Sterling Design Associates, LLC

RE: Starbucks at Academy Gateway (PPR-17-030) Review 2

Thank you for your second review. Below are responses to the written comments. Attached are the comment responses to the redline drawings. All comments have been addressed.

6 OF 21

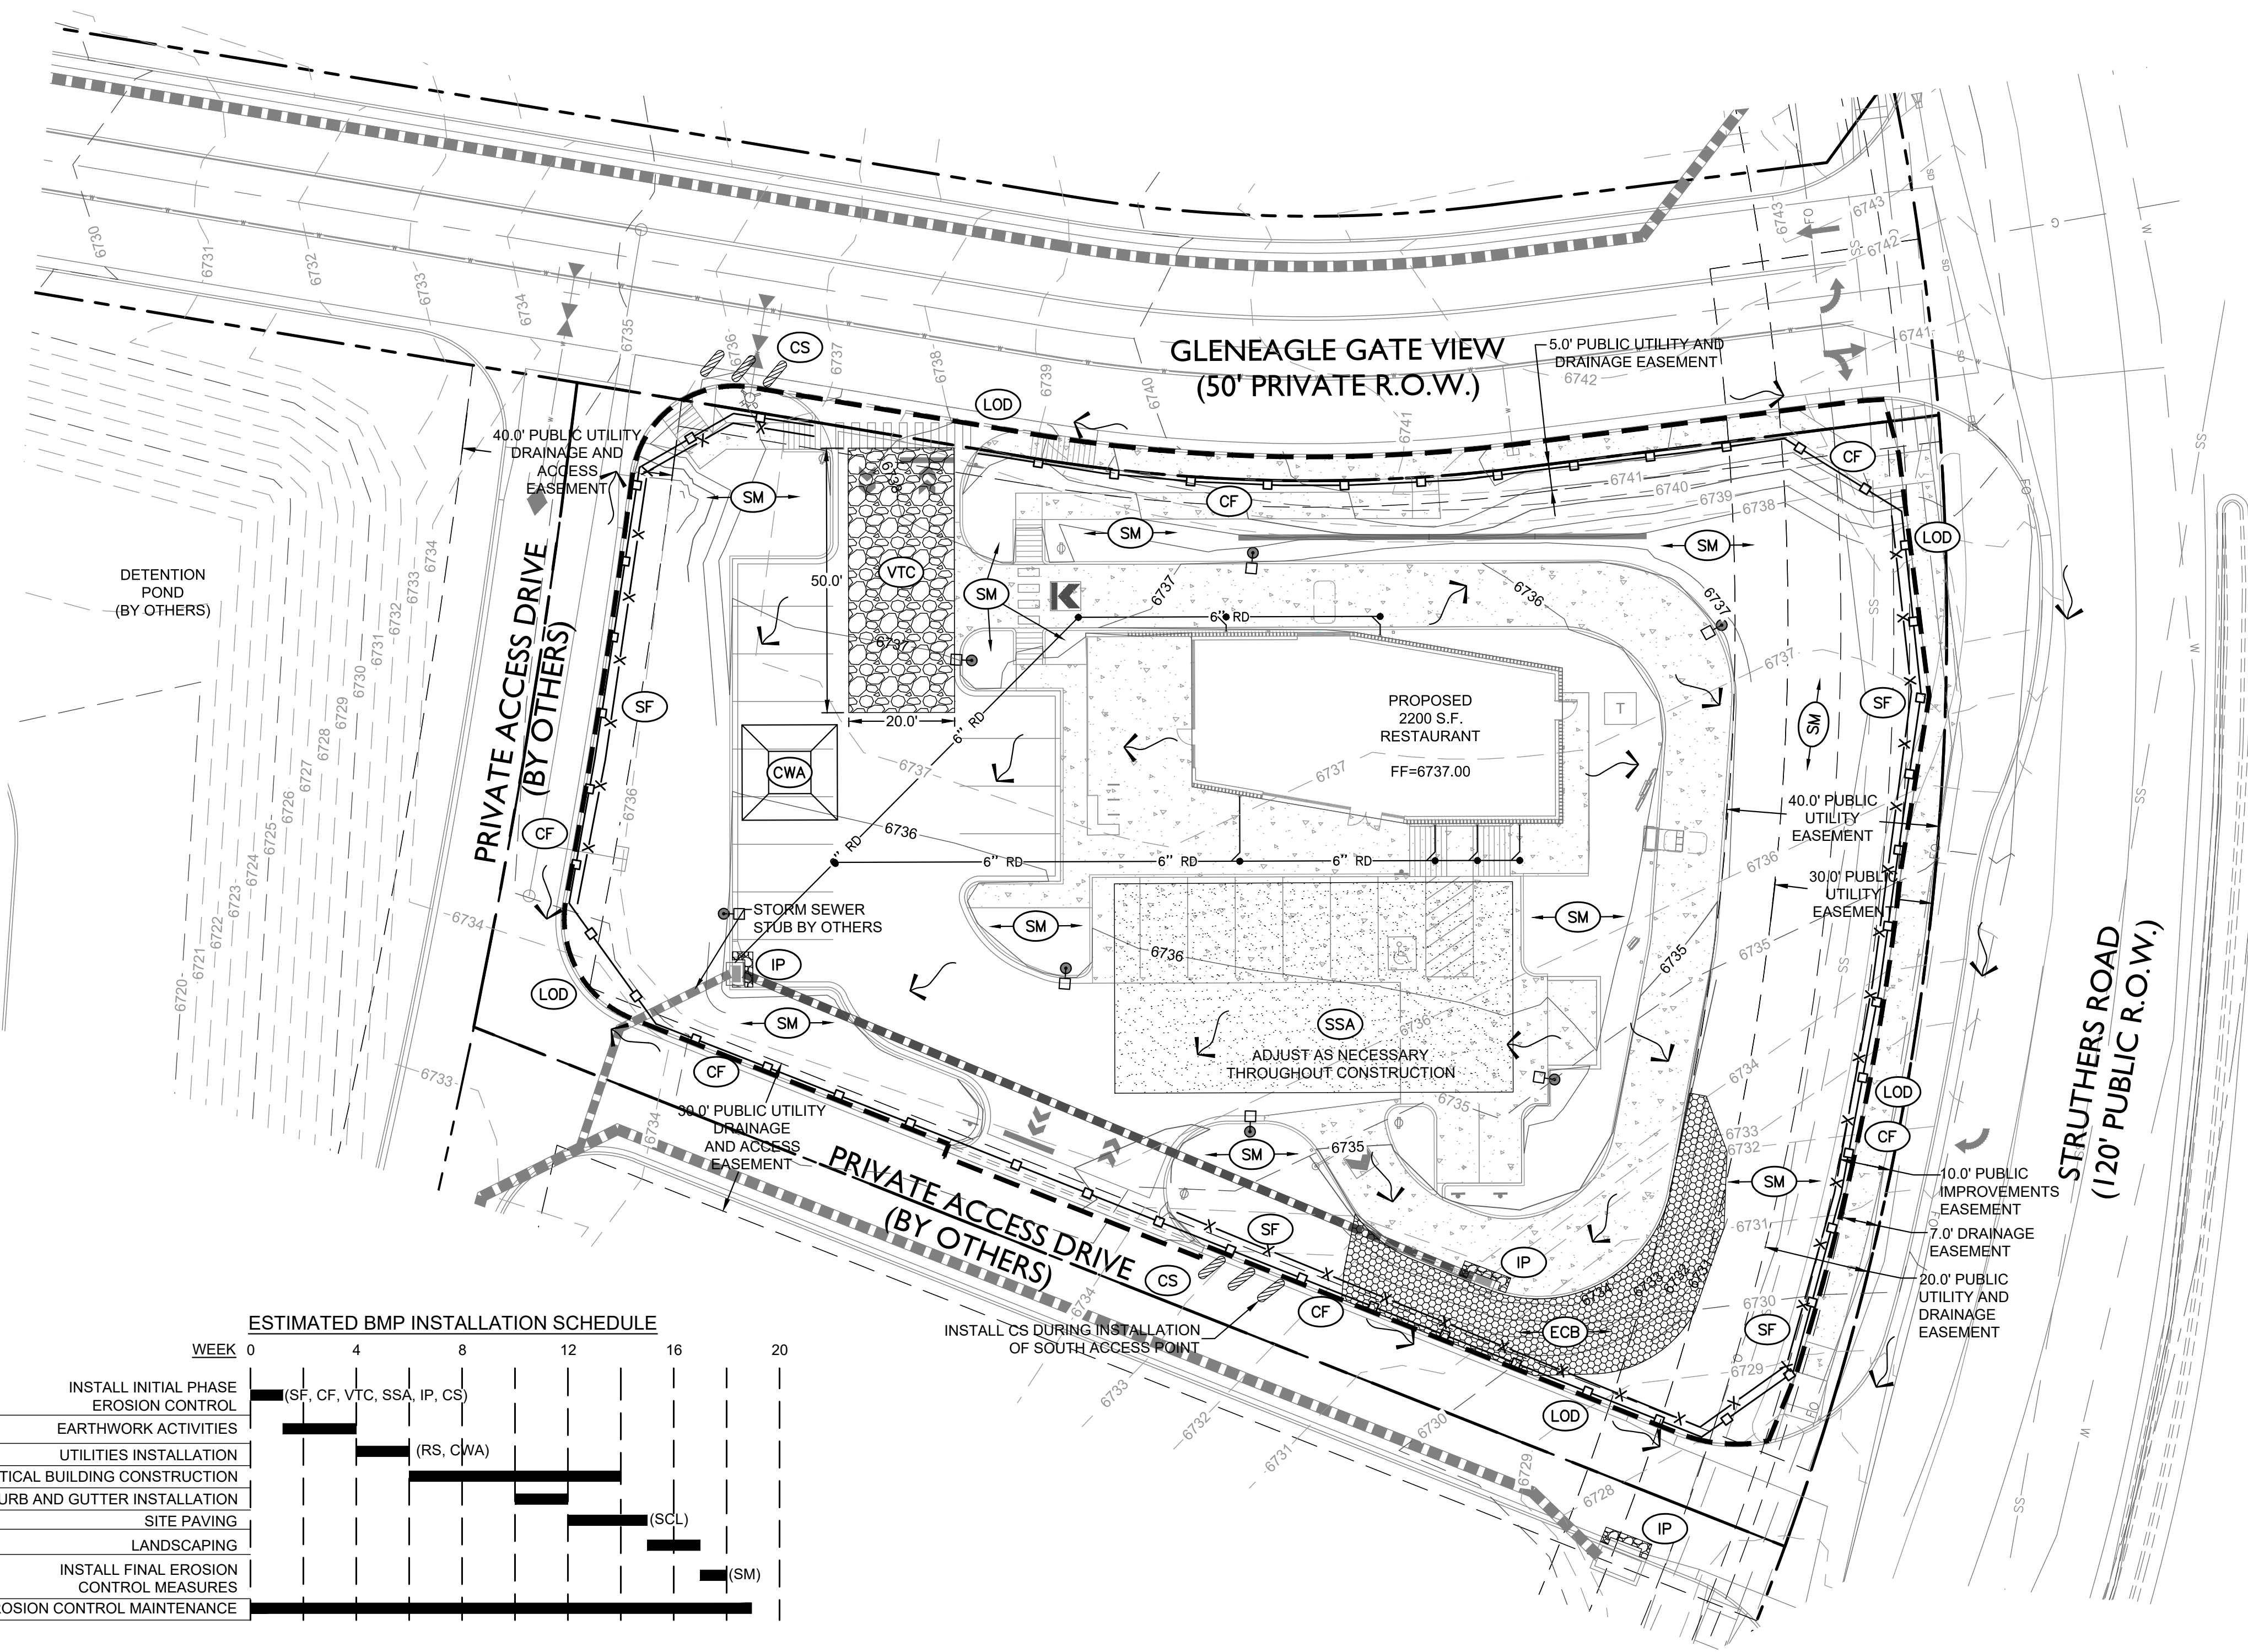
1. See redlines on the Site Development Plan document. **See new redlines.** – Revised, inlet protection provided for inlet at SE private access drive to Struthers.
2. **Resolved**– Thank you.
